Appeal Decision

Decision date: 20 January 2022

Appeal Ref: APP/R4408/D/21/3279956

115 Intake Crescent, Dodworth, Barnsley S75 3NL

FRONT PORCH ELEVATIONS

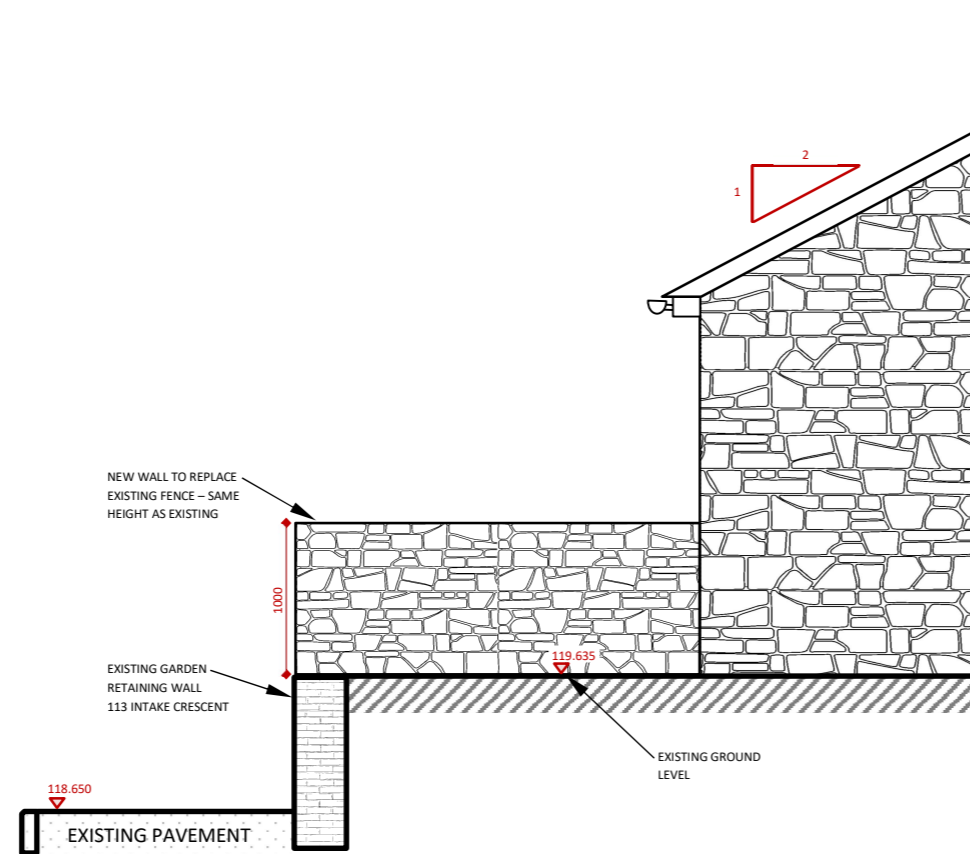
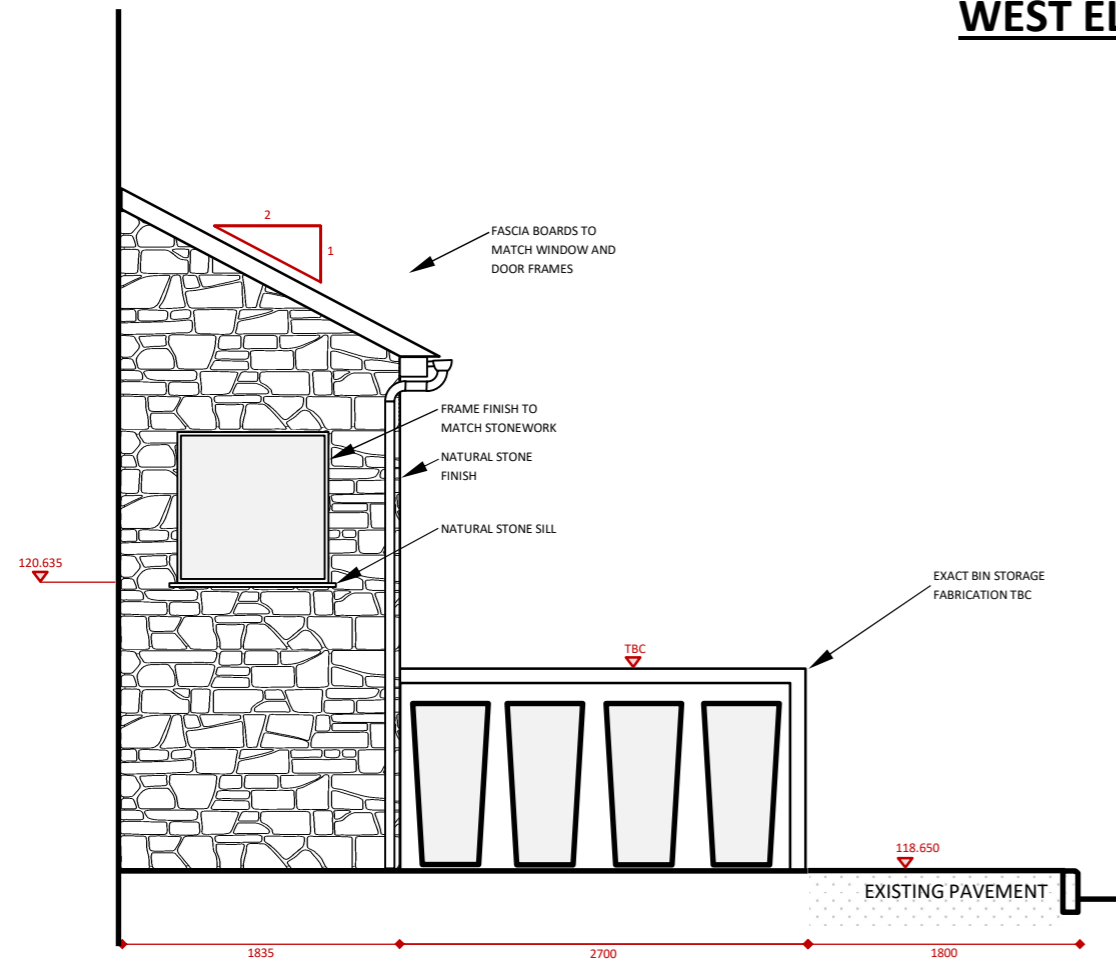
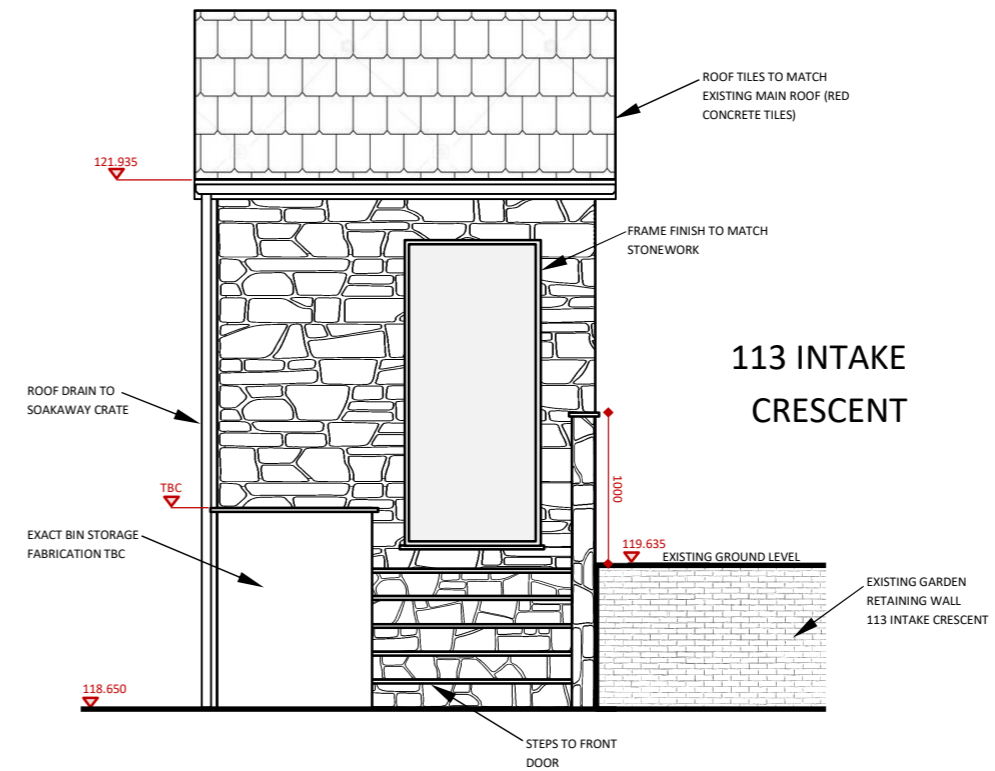
4. The walling for the proposed porch is to be faced in natural stone. I note, however, that in the appeal statement the appellant is proposing to vary the walling materials to a combination of brick and natural stone, with an illustration showing brick used to edge the stone walling. However, the elevation drawings submitted with the application have not been amended to incorporate this detail and the design intention is therefore unclear.

5. Irrespective of the uncertainty as to whether the walling of the porch is to be constructed in stone or a combination of stone and brick, I consider that the use of mainly stone for such a prominent addition would be an inappropriate building material within an estate of predominantly brick buildings. The porch

would make a jarring contrast to the host building and would be a highly noticeable feature in the streetscene. The visual harm would be exacerbated by the digging down to the side of the porch to create the parking area which would make the porch, together with the steps and side walling, a much more prominent, discordant feature.
